**WEST SUSSEX COUNTY COUNCIL
INFRASTRUCTURE CONSULTATION**

DATE: 18th February 2009

**SUBJECT: CL/1/09/ - Conversion of existing barns to 4 no commercial units (B1 use)
and single dwelling**

Longfurlong Barns Longfurlong Farm, Longfurlong, Clapham, West Sussex

SITE PLAN 1:200

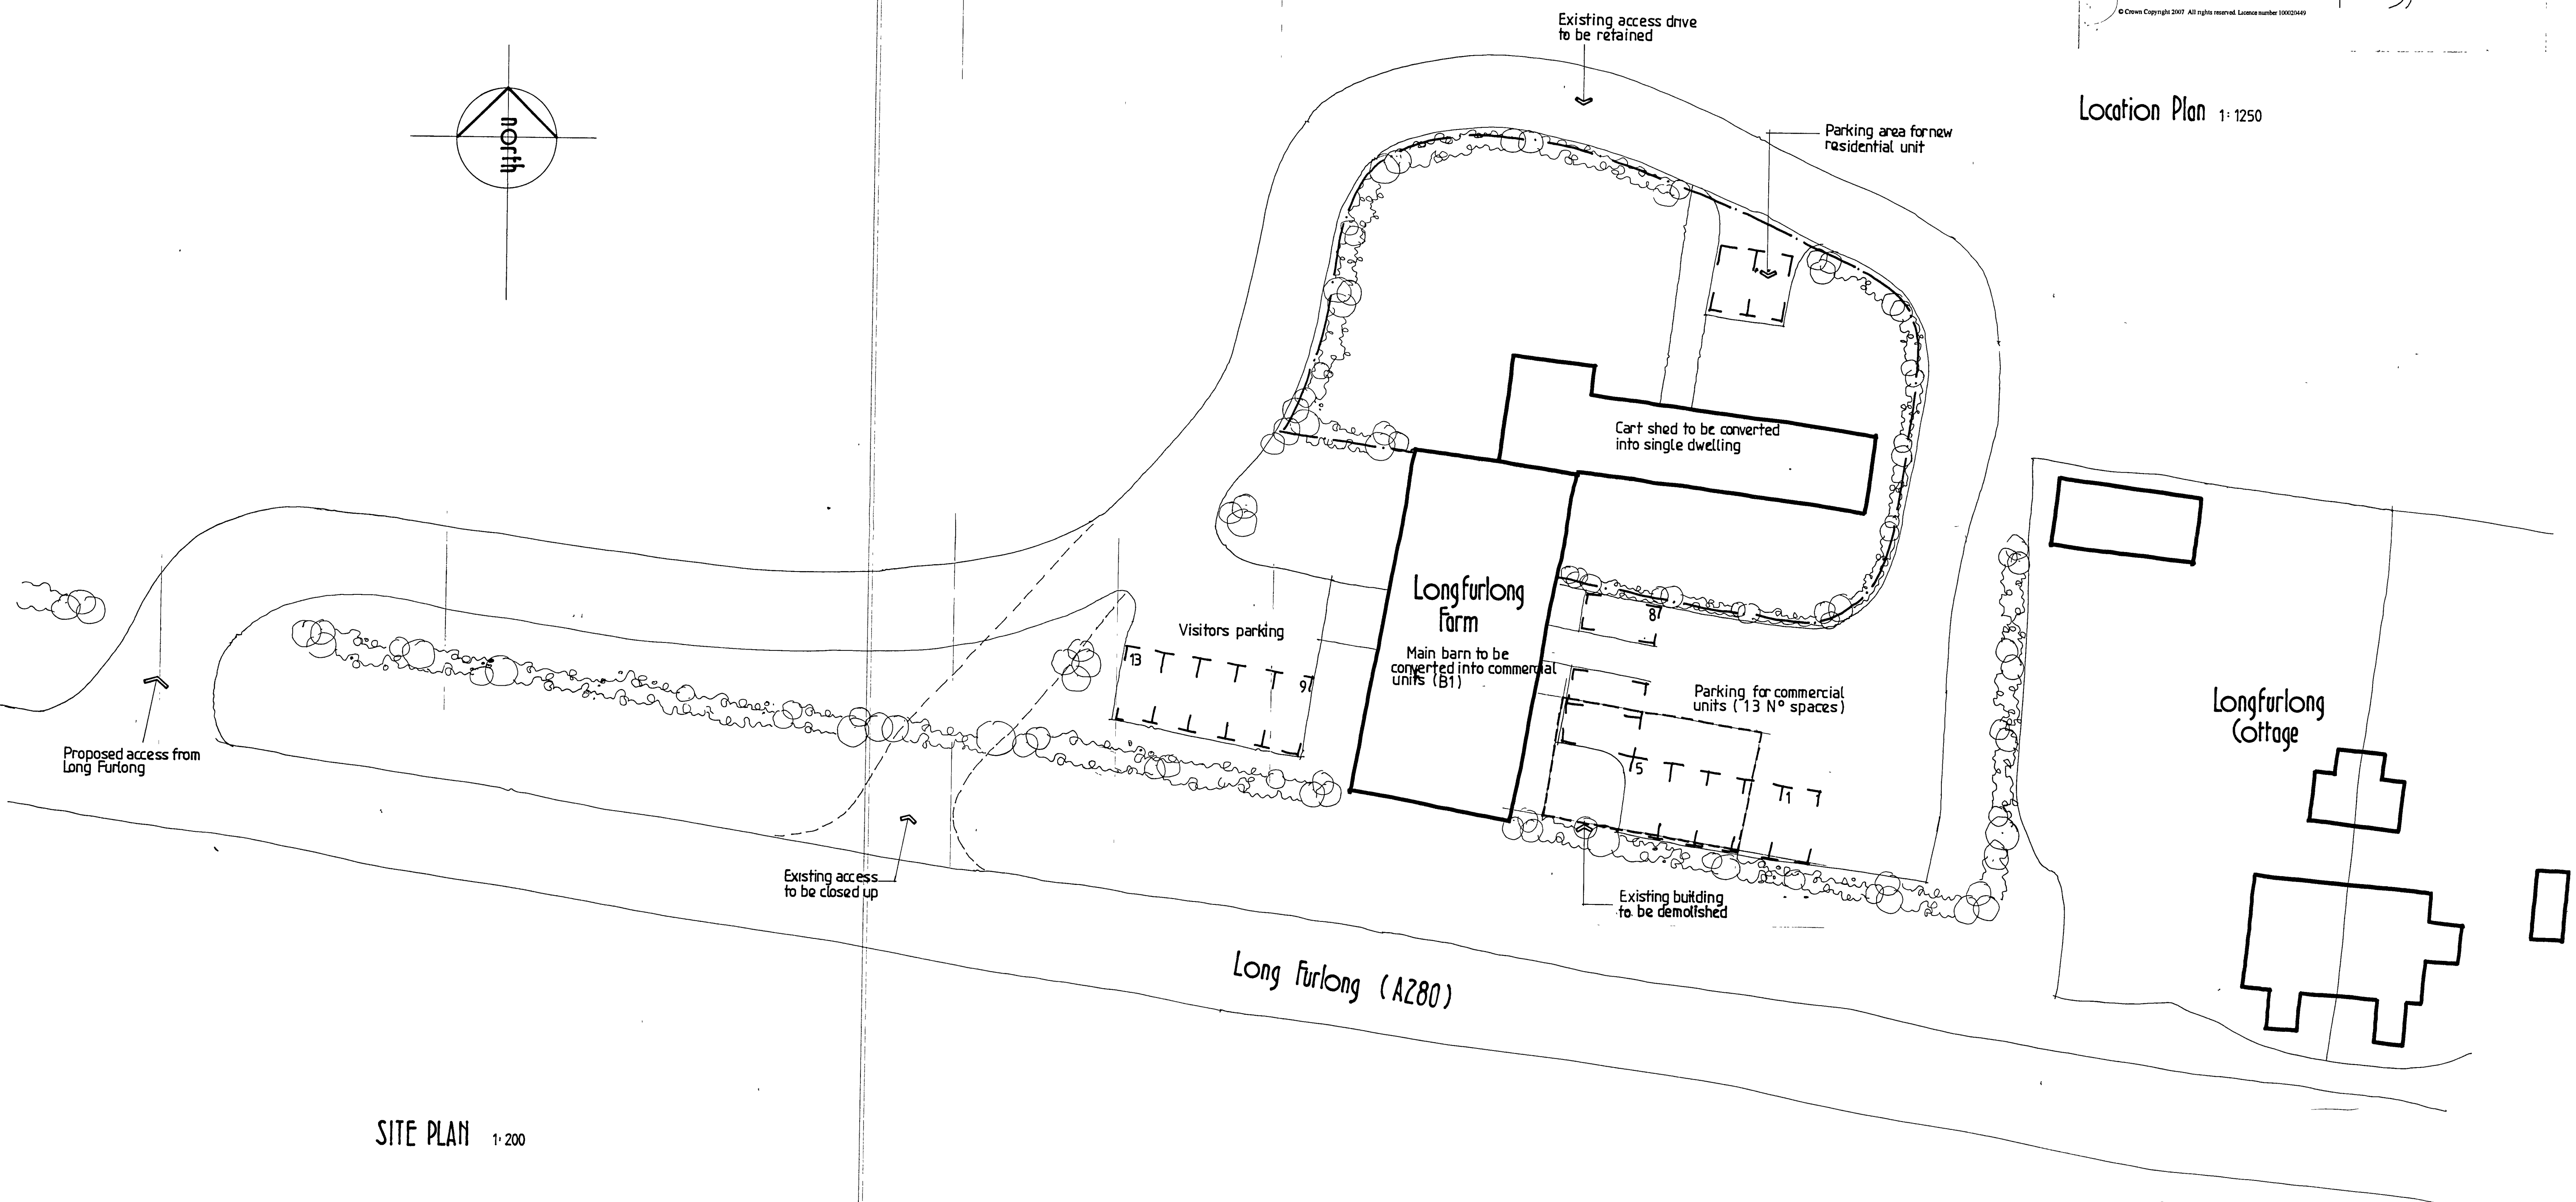
The site accesses directly onto the A280 Long Furlong, which has a speed limit of 60mph and provides an important function in linking the A27 and A24 allowing traffic to by pass Worthing. The A280 from Patching to Findon is recognised as a county road of strategic importance. The formation of a new access onto the A280 must therefore be designed with adequate visibility and access geometry. Under current guidance, visibility splays of 2.4 by 215metres would be required, or visibility splays demonstrated that are concurrent with the 85th percentile vehicle speeds as recorded by means of a 7 day traffic survey. The Applicant has failed to demonstrate that satisfactory standards of visibility are achievable from the access, particularly in the easterly direction.

Further to this the access itself should be designed in accordance with TD 41/95 of the Design Manual For Roads and Bridges. Specifically the access should be designed to accommodate the largest vehicle expected to visit the site (I anticipate this would be a refuse vehicle) and designed with sufficient kerb radii and taper to prevent a vehicle from over running the centre line when exiting. This does need to be further demonstrated.

In terms of car parking, the application form appears to state that 19 parking spaces are proposed. Only 15 spaces are shown on the drawing. In regards of the B1 use and under the WSCC Parking Standards, the proposed floor area of 342sqm would allow a maximum provision of 11 parking spaces. The provision of 13 spaces therefore exceeds this. The provision of 2 car parking spaces for the dwelling is within the parking standards.

The proposed access is unsatisfactory to serve the proposed development by reason of inadequate width and visibility in conflict with policies DEV4 of the WSCC Structure Plan and GEN7 of the Arun District Local Plan.

The formation and use of an additional access to the public highway (A280 Long Furlong) at this point would add to the hazards of highway users to an unacceptable degree in conflict with policies DEV4 of the WSCC Structure Plan and GEN7 of the Arun District Local Plan.
